## PARKS AND COMMUNITY SERVICES DEPARTMENT

October 18, 2024

**Subject: Grandview Reserve Phase III PUD Development Plan and Preliminary Plan, 2<sup>nd</sup> Submittal (PUDSP-24-001)**

GRANDVIEW RESERVE PHASE 3 PUD DEVELOPMENT PLAN & PRELIMINARY PLAN

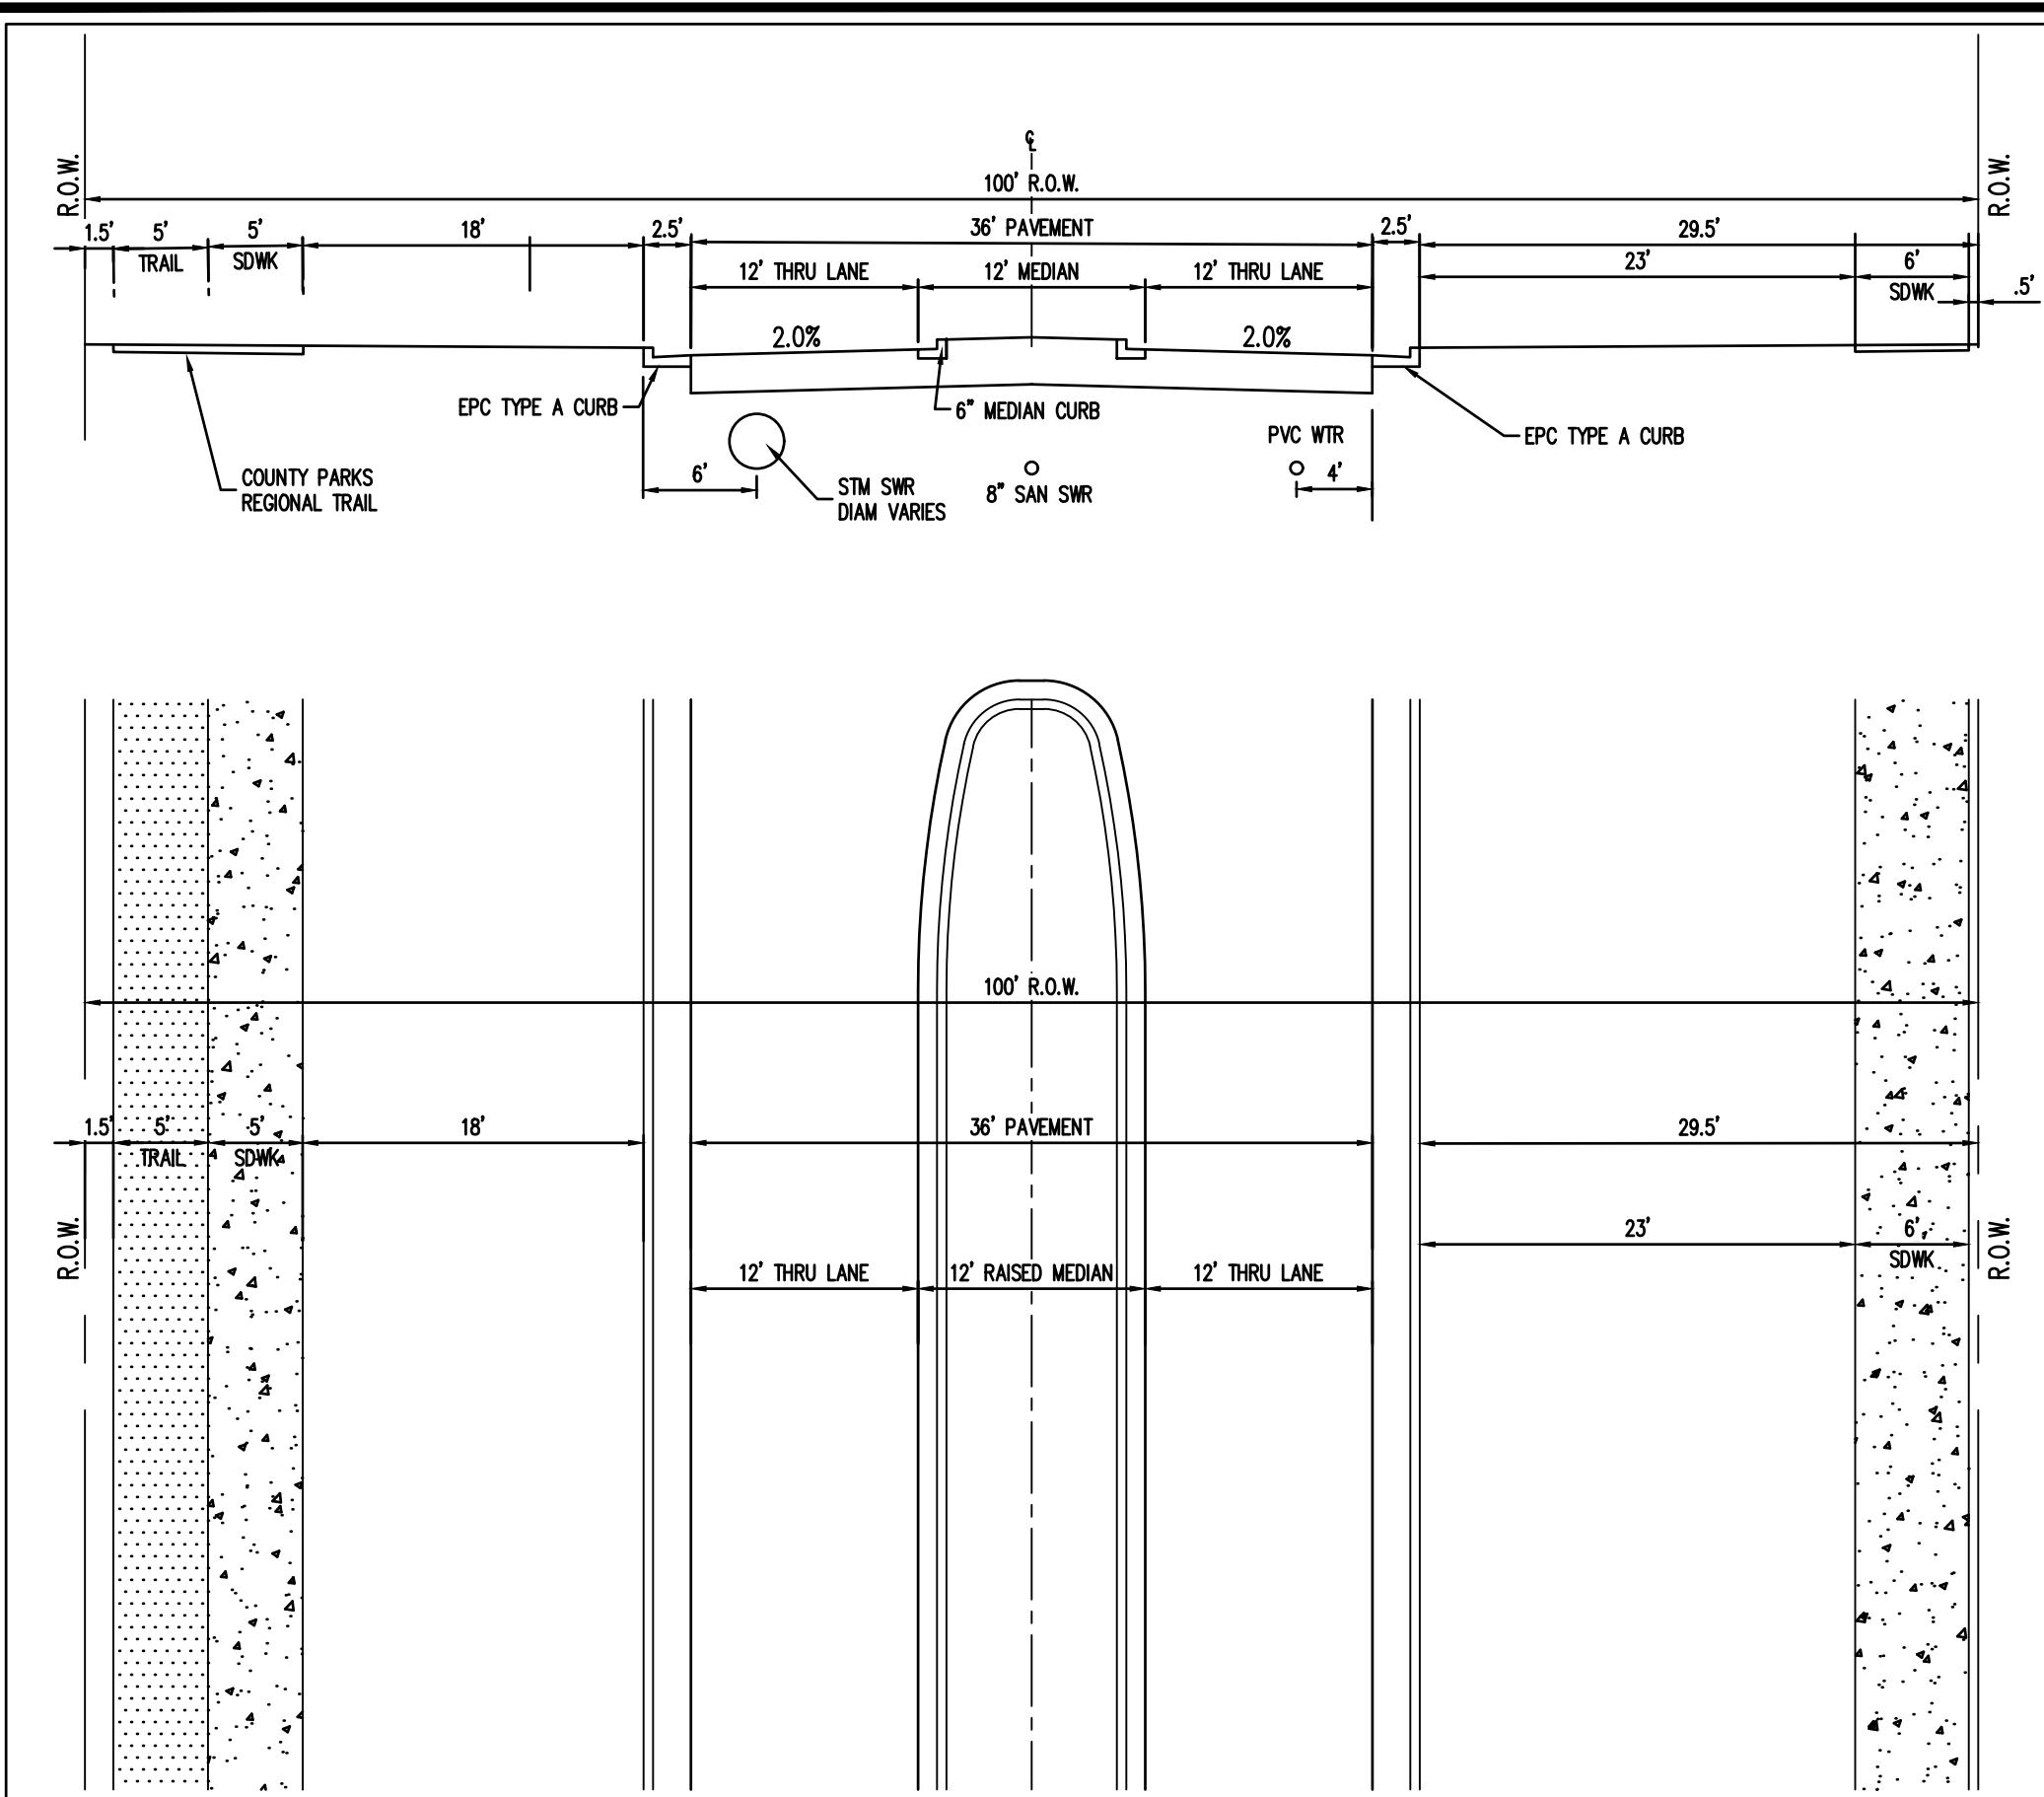
However, the Land Use Table shown on the first page of the PUD Development Plan and Preliminary Plan, however, does not properly list all the available open space, and only highlights the neighborhood park tracts, thus inaccurately showing that the project does not meet the Land Development Code's 10% open space requirement. Staff highlighted and calculated all tracts that meet the definition of open space, which include the neighborhood parks, passive open space, trail corridors, and landscape areas. Staff spoke with the applicant's representative, and they verified the staff's findings. As such, the application has met and exceeded the 10% open space requirement.

GRANDVIEW- PHASE 3- PUD PLAN
 LANDSCAPE PLAN

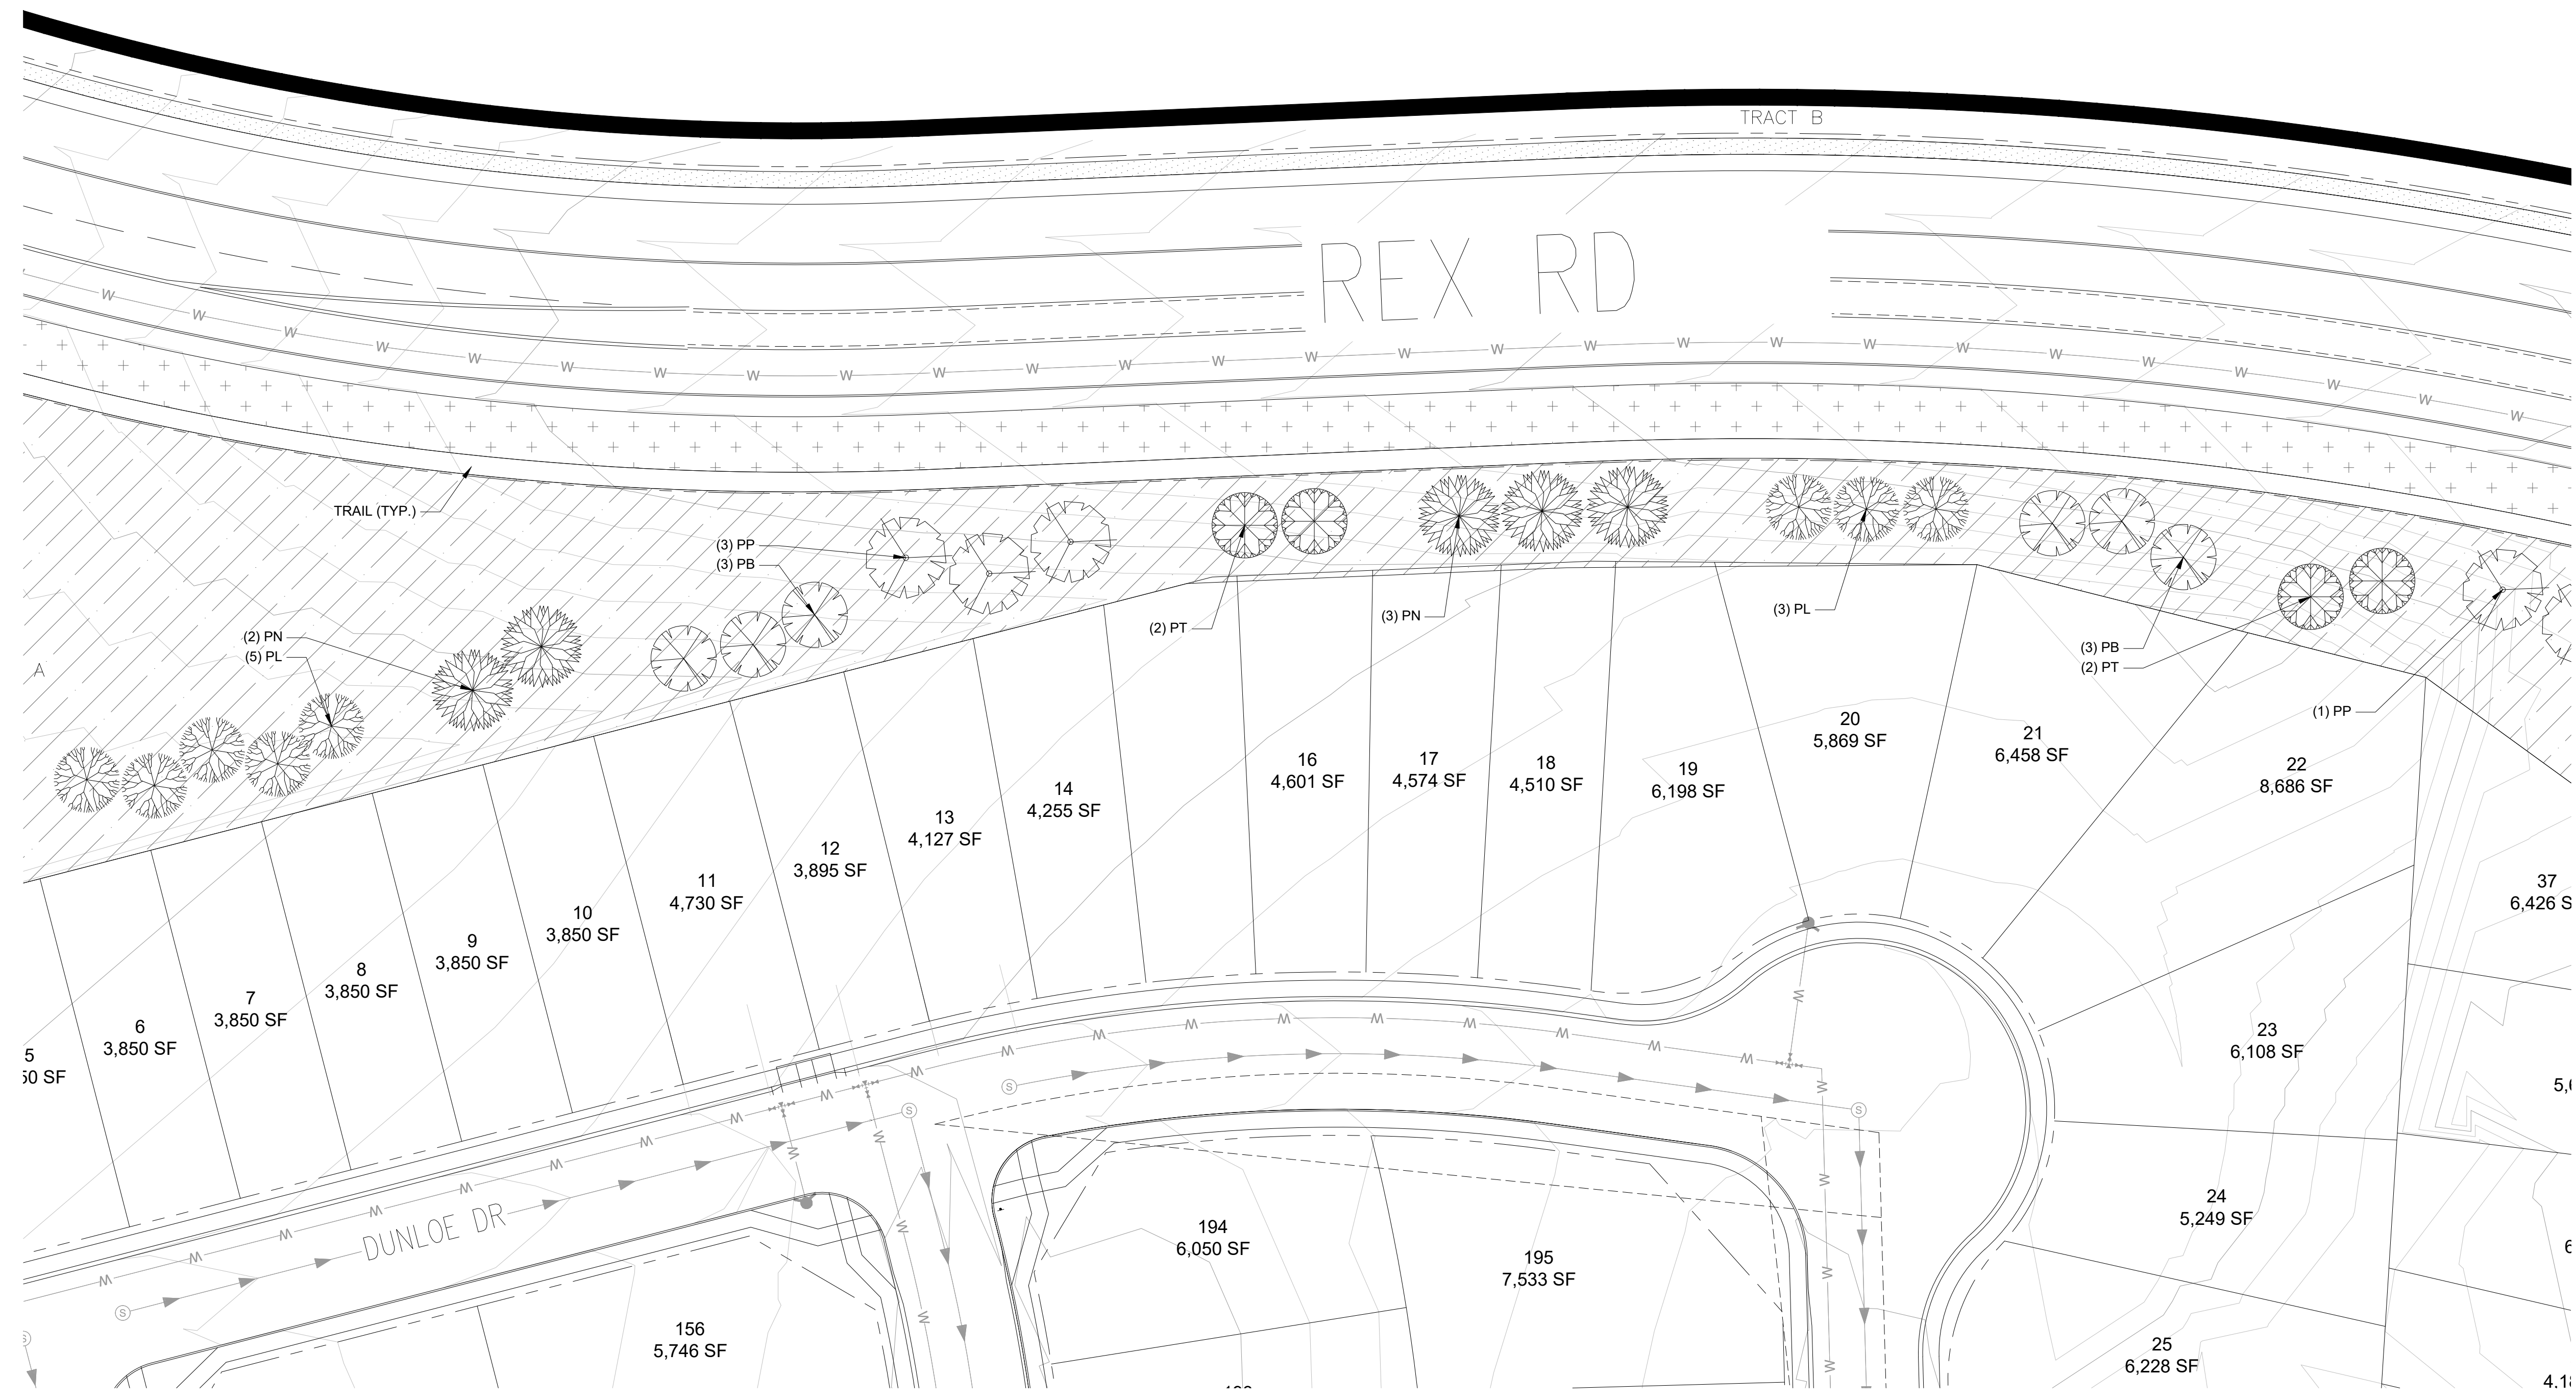
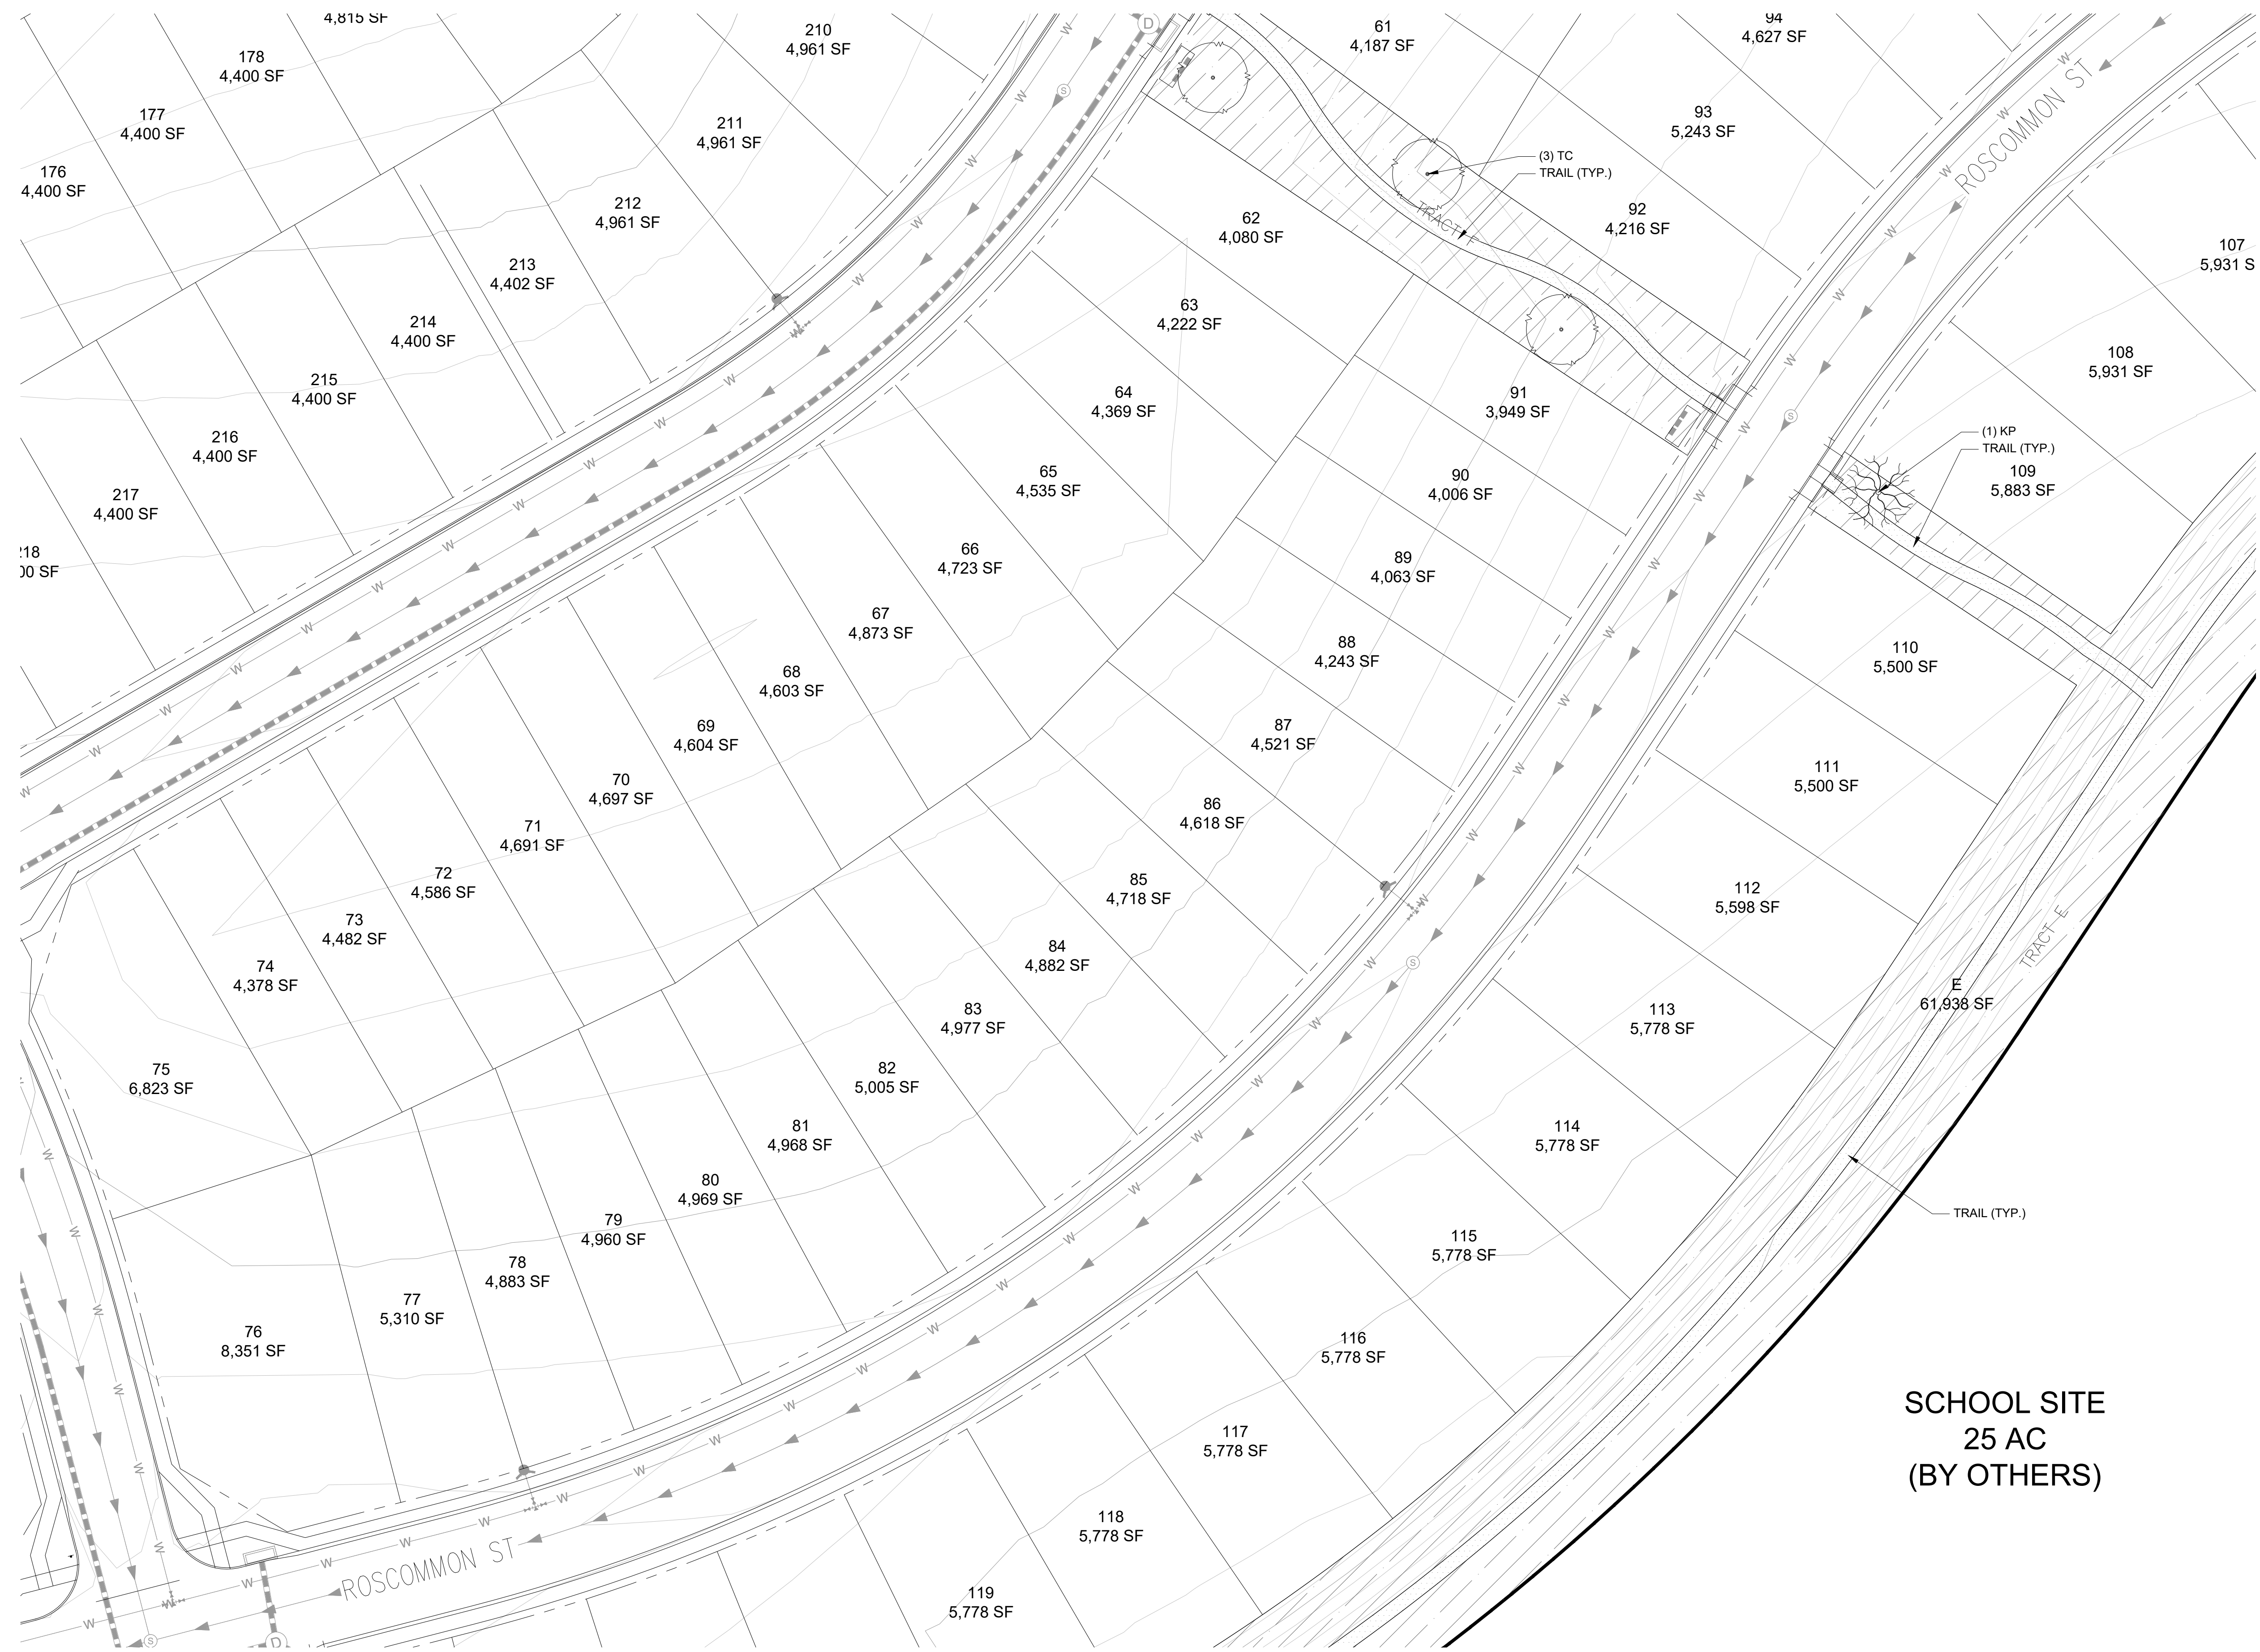
As mentioned, the Phase III PUD Preliminary Plan currently shows approximately 16.78 acres of open space which includes the locations for proposed neighborhood pocket parks in Tracts D and I, common open spaces, an interconnected internal trail network, and various landscape buffers (see highlighted Landscape Plan). Combined, these open spaces constitute approximately 16.3% of the total project area of 102.82 acres, or 21.5% if the 25-acre school tract is not included in the overall project acreage.

EPC staff is encouraged by the applicant's willingness to provide extensive recreational amenities for its residents of Grandview Reserve and citizens of El Paso County through the development of an expansive and connected park, trail, and open space system. Staff recommends that the applicant submit detailed site plans for the proposed neighborhood parks and include multi-generational recreational amenities such as a playground, multi-use turf field,

and/or seating and picnic areas. The submitted Landscape Plans are rather limited and only show half of the proposed park area located in Tract I.
